PW/16072

15 February 2017

Land at Villa Maria Campbell Road Bognor Regis PO21 1NW - Proposed Variation of Condition 2 of the planning permission BR/270/16/PL for change of use of an existing residential convent (C2 Use) to student accommodation (Sui Generis).

Title:-
Proposed Second Floor Plan

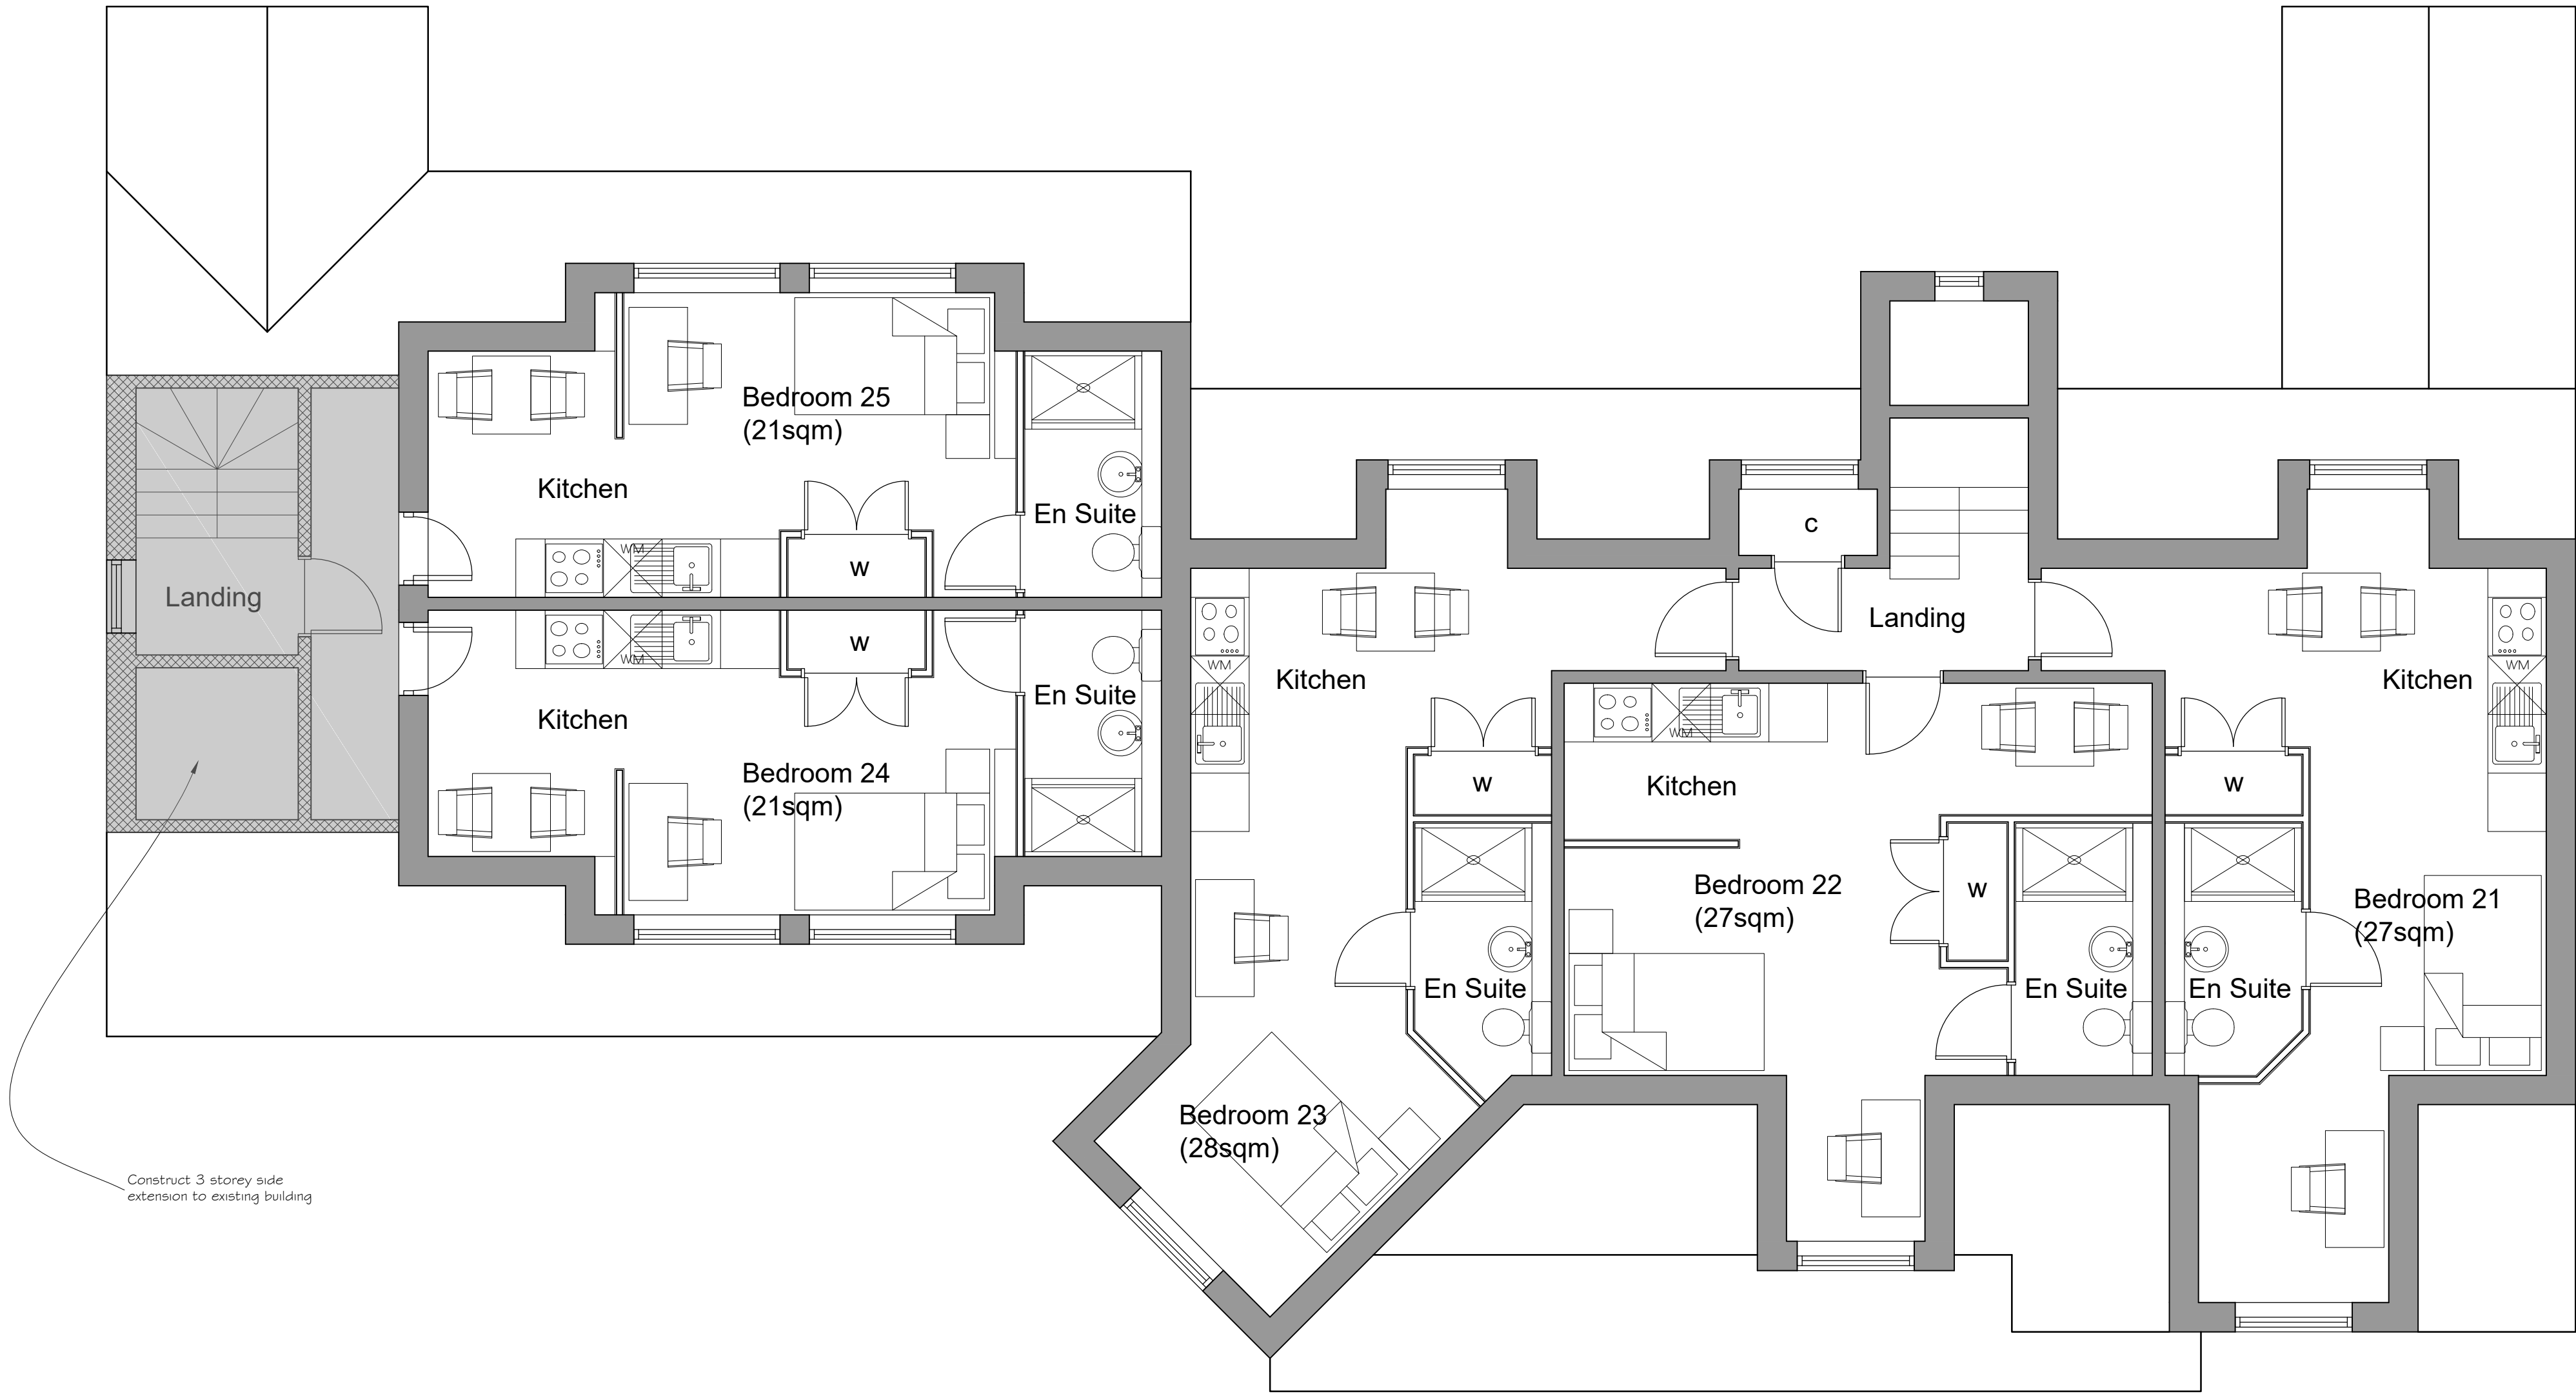
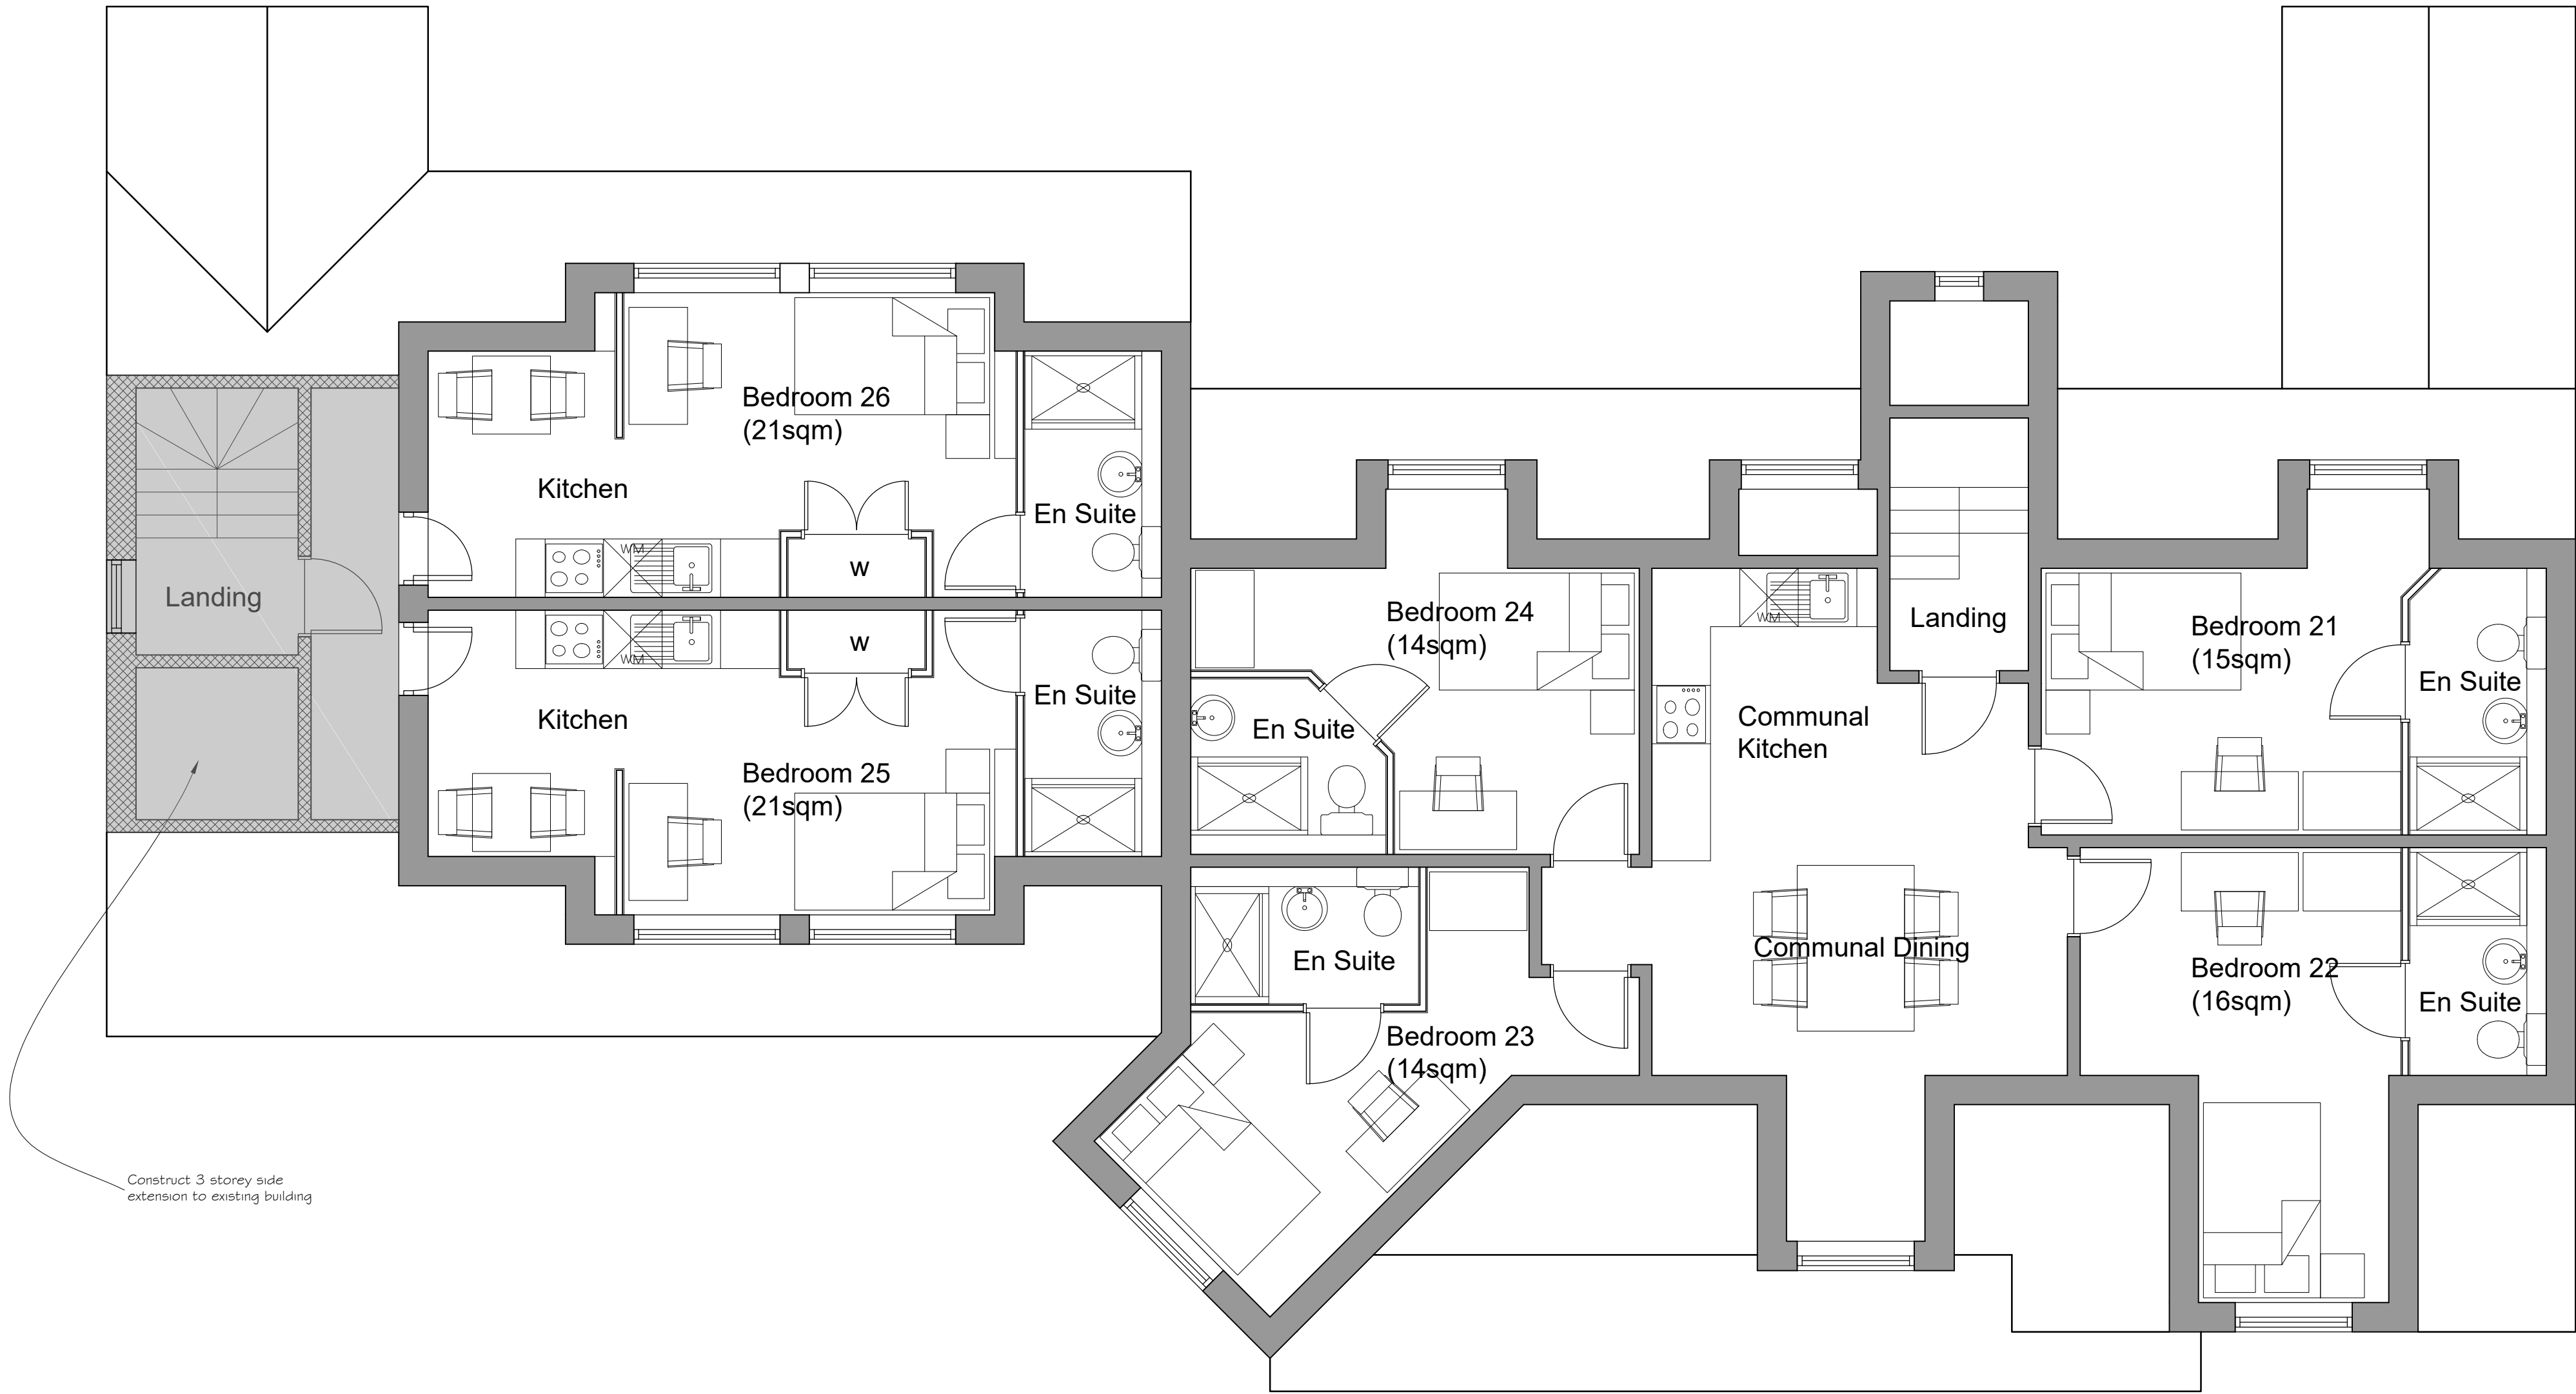
- * Amendment to second floor layout:
 - o Replacing the 3 no. large studios on the 2nd floor within the original part of the building, with 1 no. 4 bed cluster flat with shared facilities.
- Reasons for the amendment:
 - o This provides an improved balance between studios and shared flats
 - o This provides a greater number of more affordable units for the students, as the studios are more expensive than the en-suite bedrooms
 - o There is a high demand from students for the shared flats

The revised floorplan will increase the number of students accommodated within the building from 25 to 26. However, there are no additional impacts either on or off-site as the proposal remains a student car free scheme and the agreed Management Plan equally applies to this minor increase in student numbers.
